Consultation Response from KC Lead Local Flood Authority
2019/90725 Land at, Busker Lane, Scissett, Huddersfield, HD8 9JU
Demolition of existing dwellings and erection of 9 apartments
Date Responded:
05/04/2019
Responding Officer:
Aleksandra Tomczyk
Responding Ref: 0
Summary

Kirklees Flood Management and Drainage as the Lead Local Flood Authority OBJECT to this planning application as insufficient information on surface water management has been submitted.

Proposed Site Plan
Scale 1:200

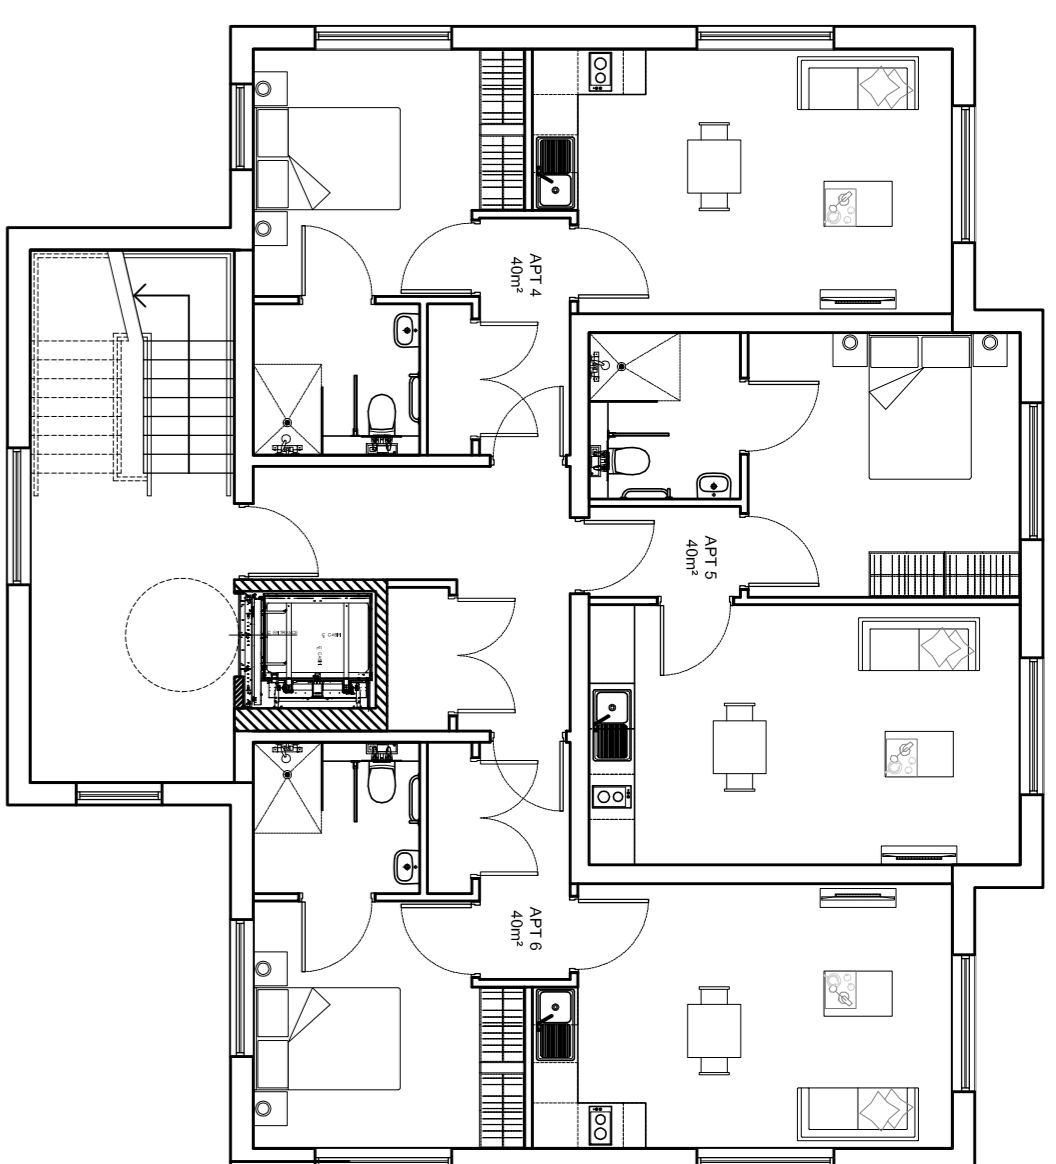
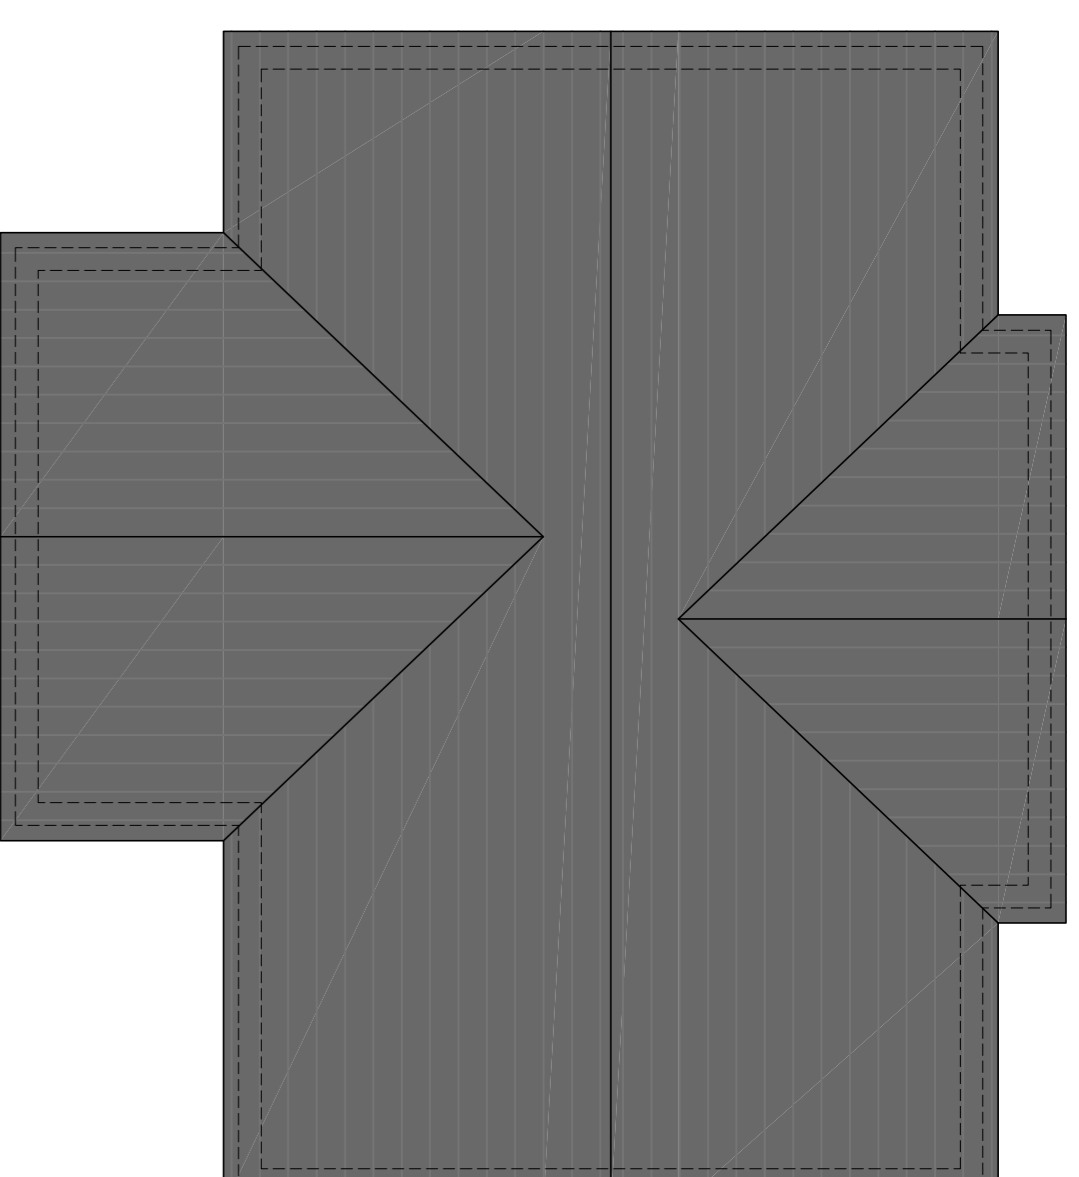
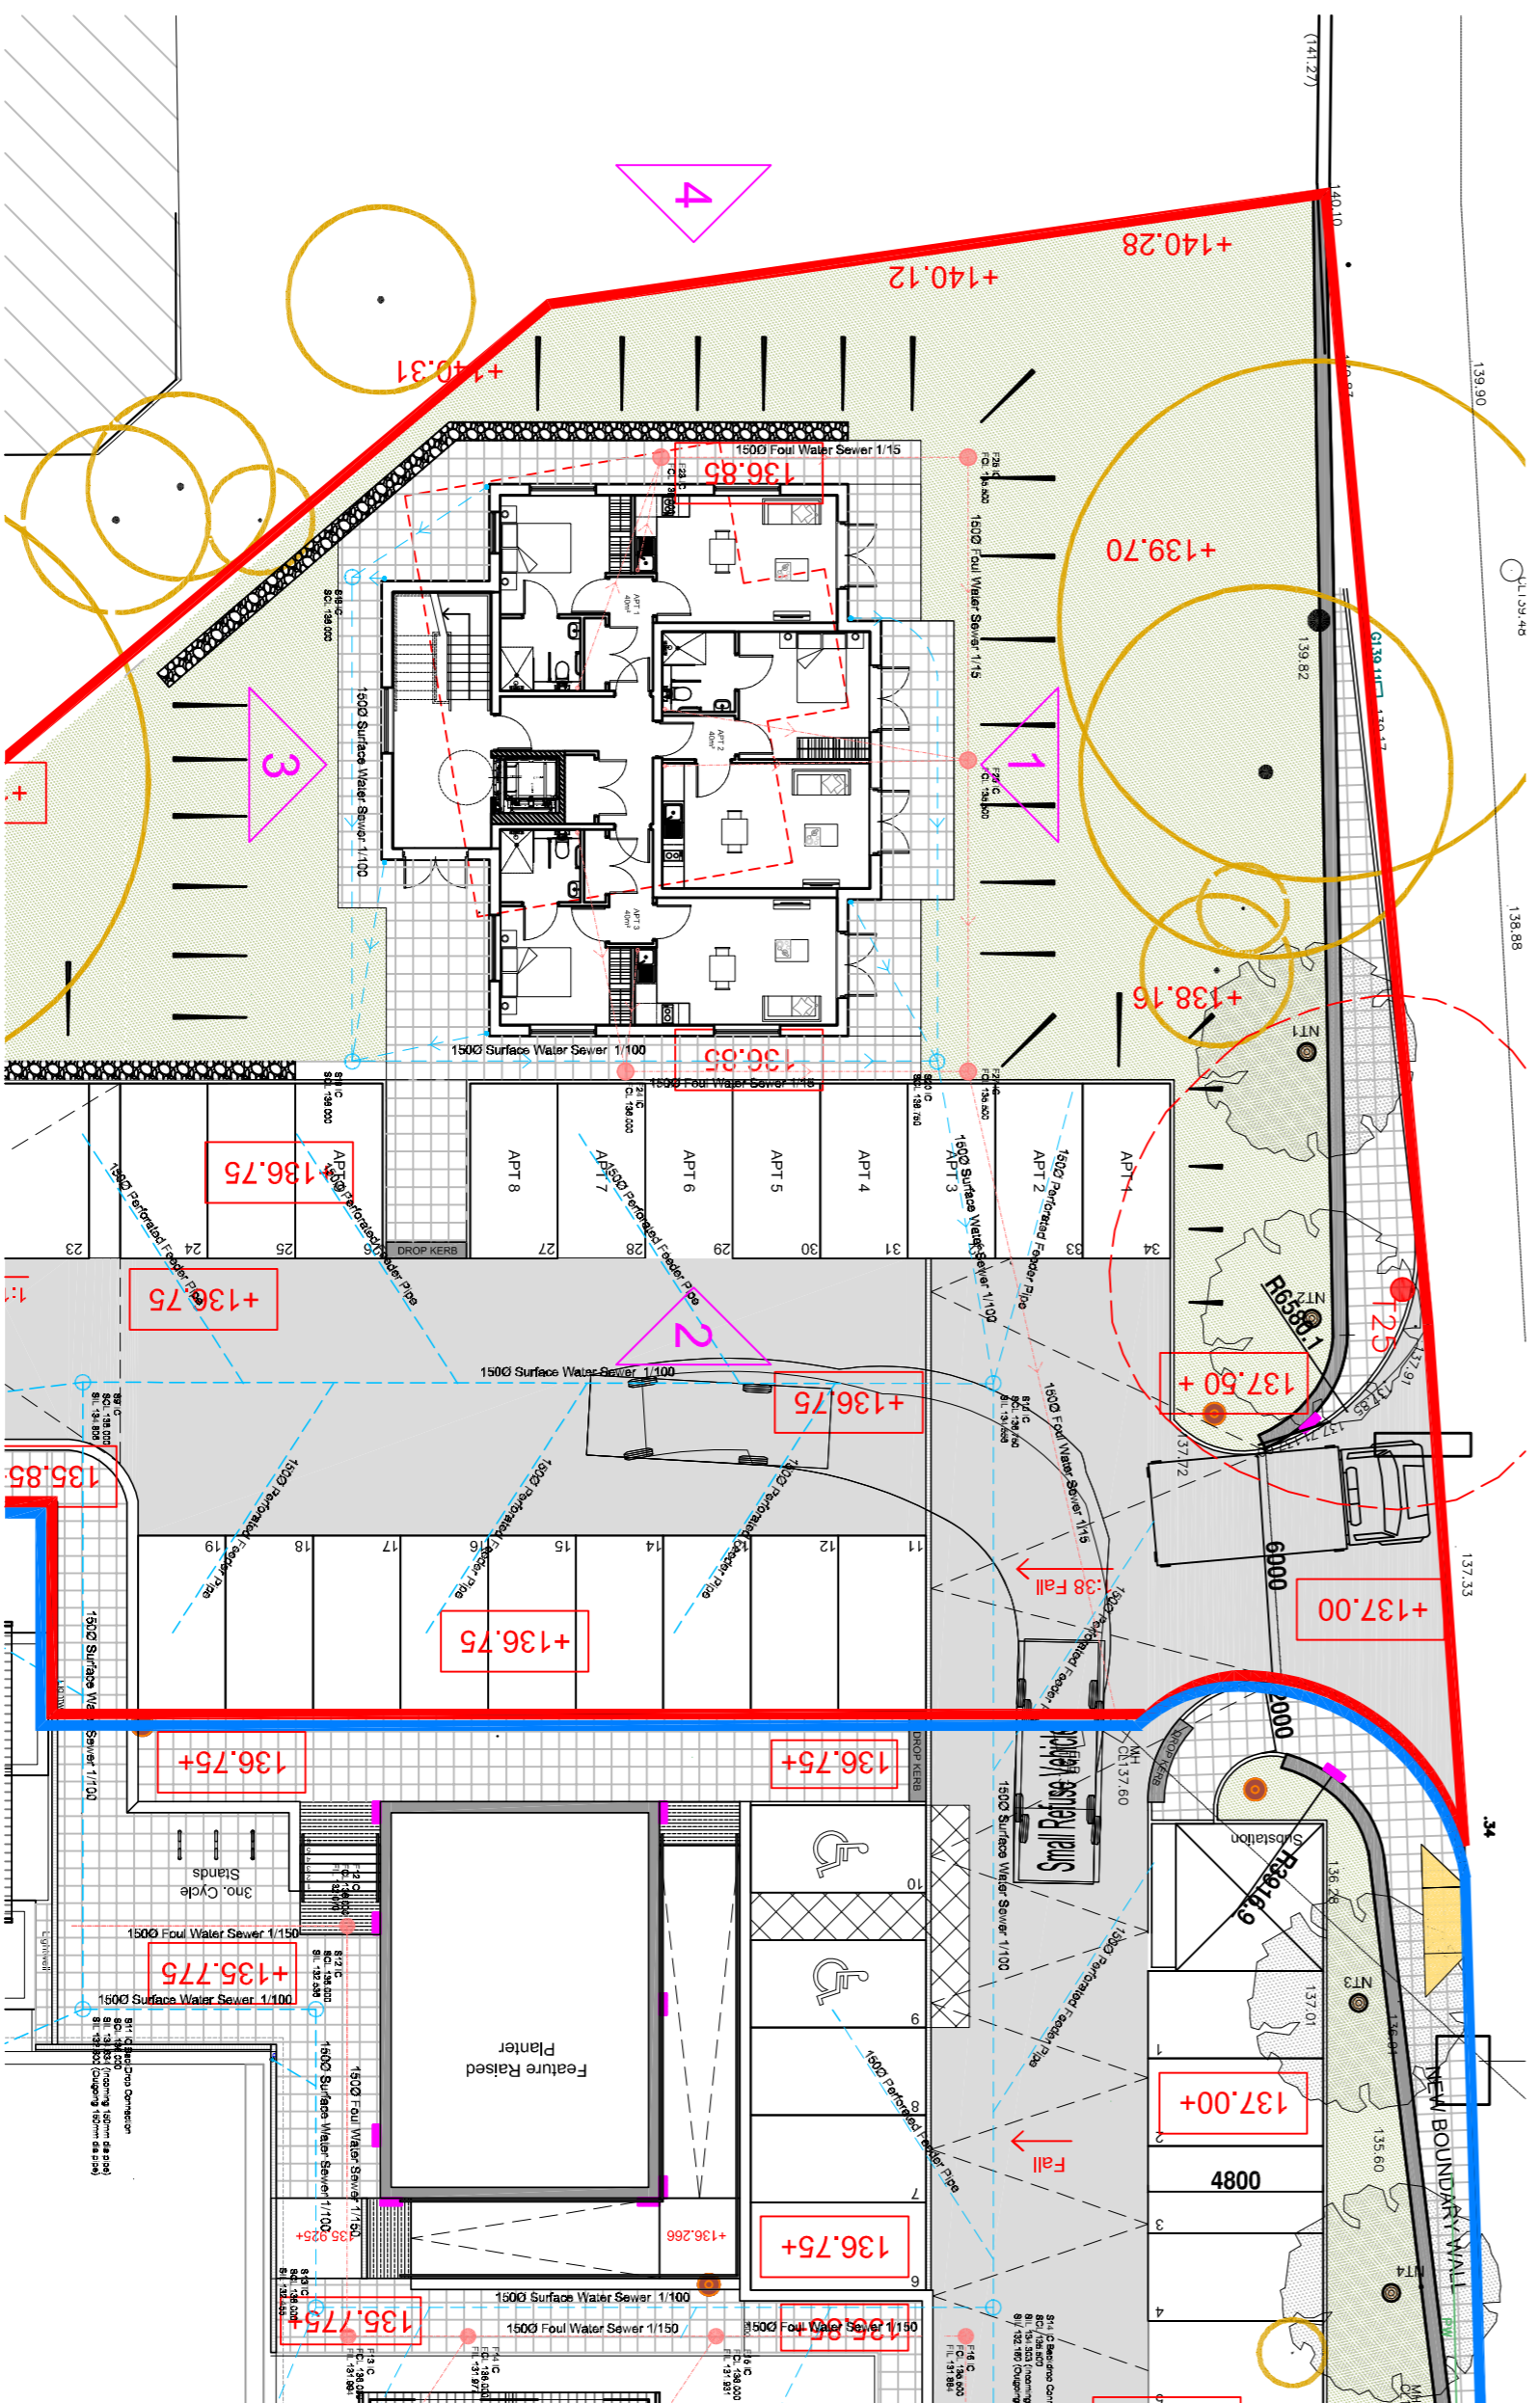
Kirklees LLFA note that the drawings submitted lack unique identifiers/reference numbers as such we are unable to refer to a specific document in any objection or approval. Few of the drawings provided by KDP Architects display the proposed alignment of drainage but provide no dimensions, levels or other fundamental information. There is no data provided over the suitability/feasibility of the proposed drainage, or whether this could have adverse impacts elsewhere.

To overcome this objection, a Drainage Strategy Report must be provided. It must address the following:

If the applicant wishes to utilise the drainage system within the neighbouring development, we require appropriate calculations showing that this system has sufficient capacity to receive the additional flows.

Kirklees LLFA highlight that this application comprises brownfield development therefore a minimum 30% reduction in surface water discharge is required, unless a justification is made for a higher rate. Evidence is required to justify why the proposed discharge is the lowest possible.
